Subject: Planning Application number 2023/44/93464/W Lingards Road, Slaithwaite

Condition 18 – Flood Routing Sufficient information has been provided with drawing ref: E19/7567/019F ‘Flood Routing Plan’. We recommend that this condition can be discharged.

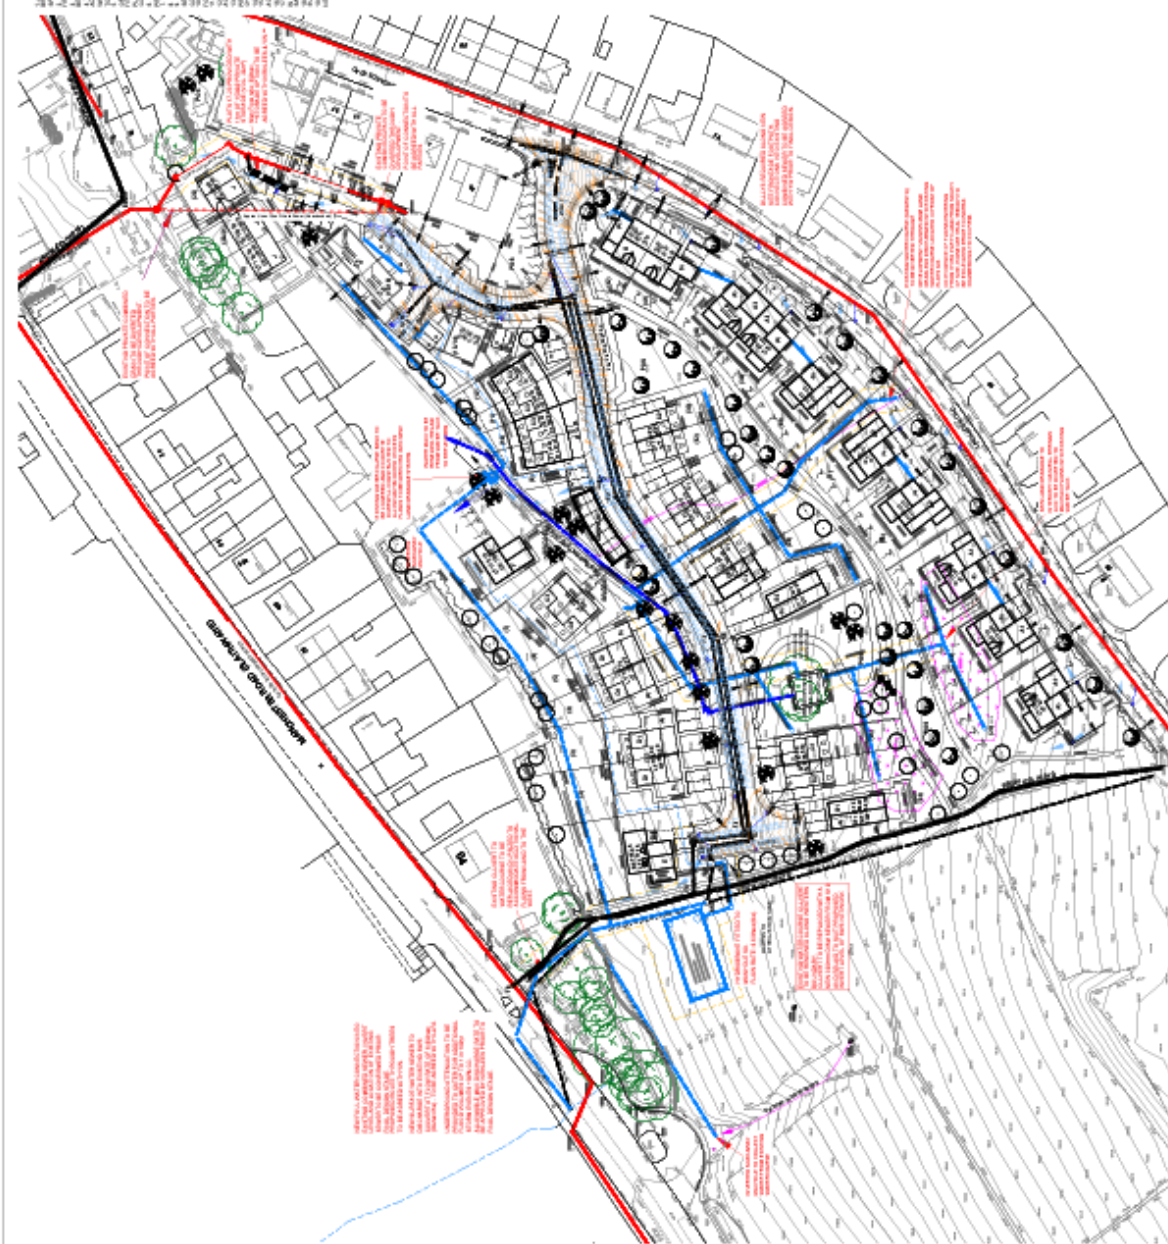
- The underlying principle, on which the proposed flood routing proposals are based, is false. It is technically and legally inappropriate to direct all the exceedance (flood) flows into the open water channel running West to East across the site.

- In hydraulic terms the water channel (We have to stress IT IS NOT a legally defined watercourse) through the garden and downstream of Far Lower Wood Farm cannot take the increased “exceedance” flood flows.

- In hydraulic terms the concrete overflow arrangement, just before the water channel enters the garden of Far Lower Wood Farm, is extremely crude and will not adequately protect the residents of Far Lower Wood Farm from flooding. At the same time the proposals for dealing with the overspill from the crude overflow are primitive, to say the least. This will almost certainly lead to flooding of properties on Manchester Road and the domestic buildings of Far Lower Wood Farm.

- The land drainage system along the northern edge of the site is hydraulically inadequate to receive the total exceedance flows or any part of the site thereof.

- In effect the exceedance (flood) flows are being wilfully directed to a position where they cannot be adequately dealt with. We cannot understand why the developer and the Council cannot see this, despite it being noted several times in our written comments regarding this development AND in response to the application for discharge of planning conditions. Why will the Council and the developer not listen to members of the public who have very significant professional drainage expertise and experience?

- We have previously indicated that there is a relatively simple and inexpensive solution to this problem, involving minor reprofiling of road levels and discharge of exceedance (flood) flows down onto Manchester Road, at the Western end of the development site. Should you wish to discuss this fairly simple option please respond by email to the author of this email submission.
